HILLS OF GOLD WIND FARM – SSD 9679

Submission by Susie Hooper

28 January 2021

Photomontage 19 (AD23)

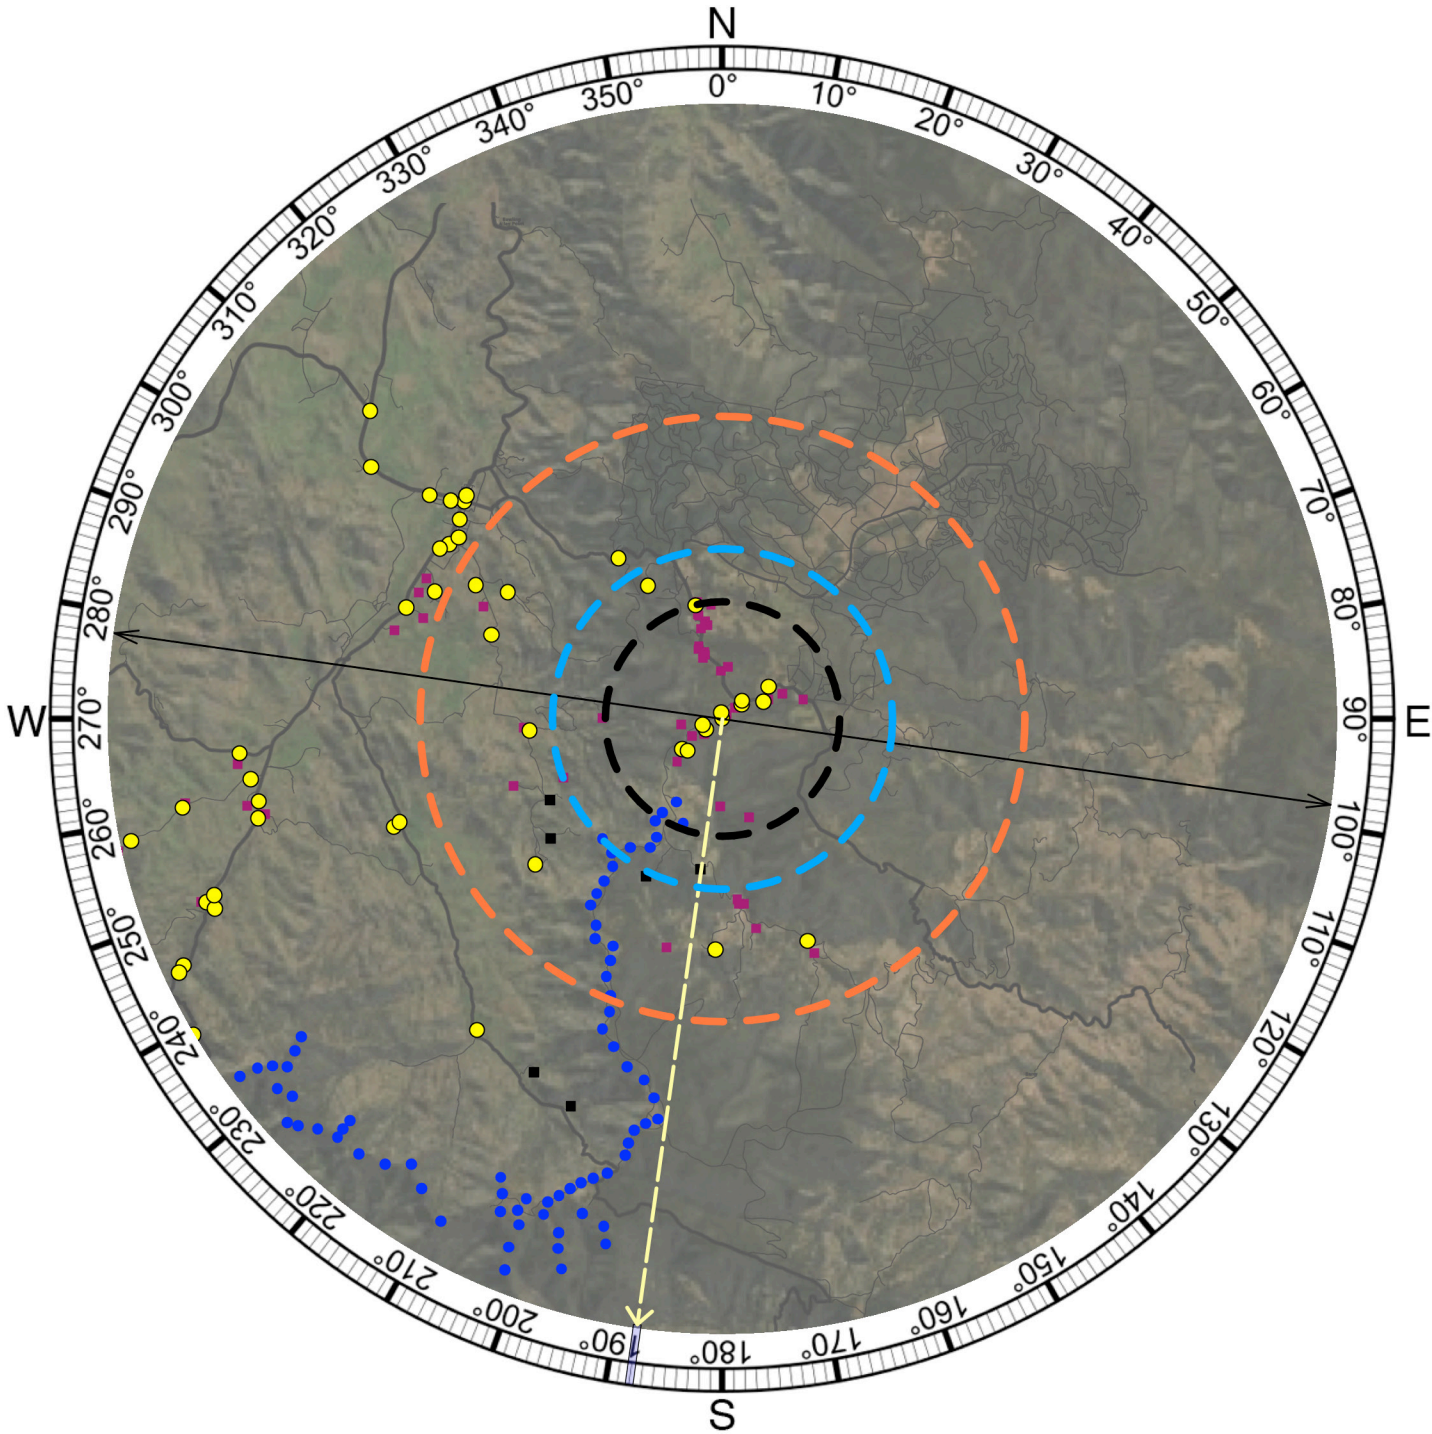
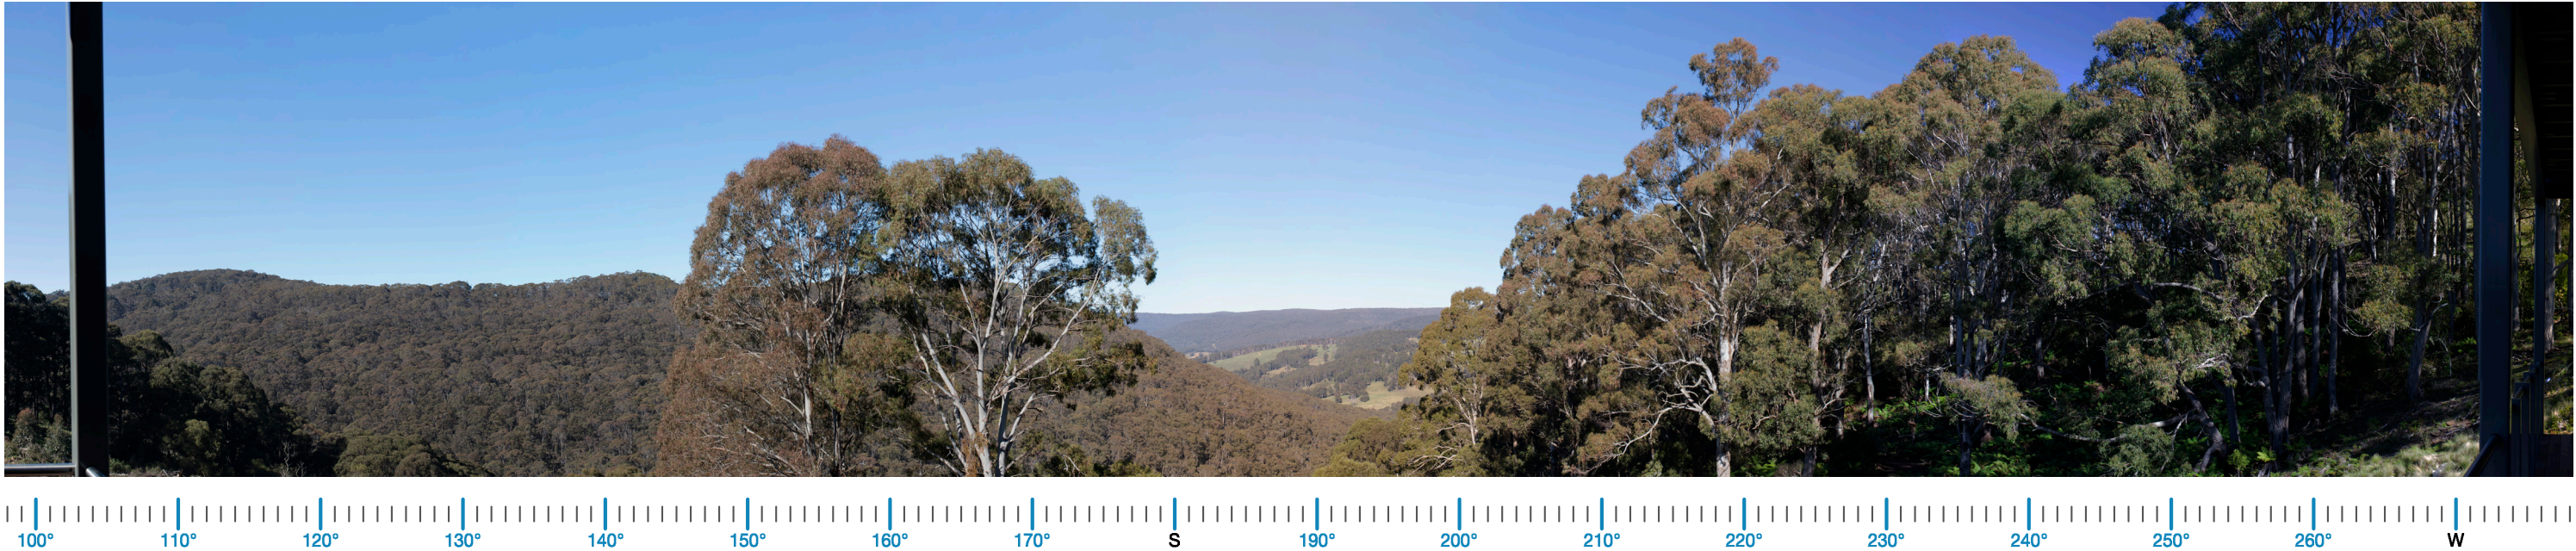
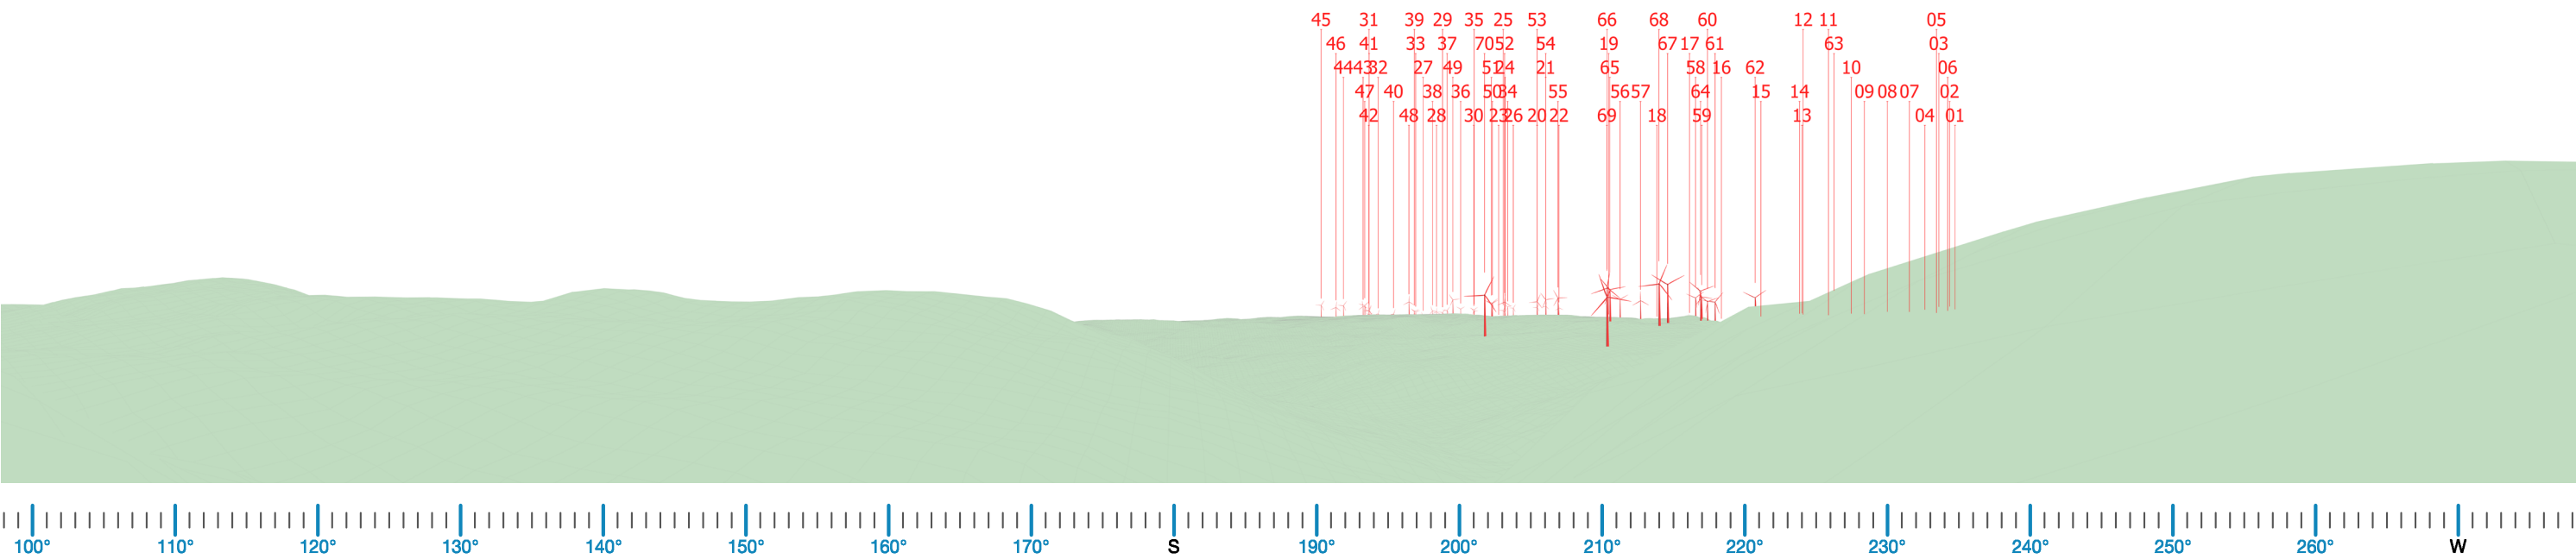
As has been the case from when we were advised of the placement of the wind turbines, I would like the Turbines numbered WP 65 to WP 70 to be removed.
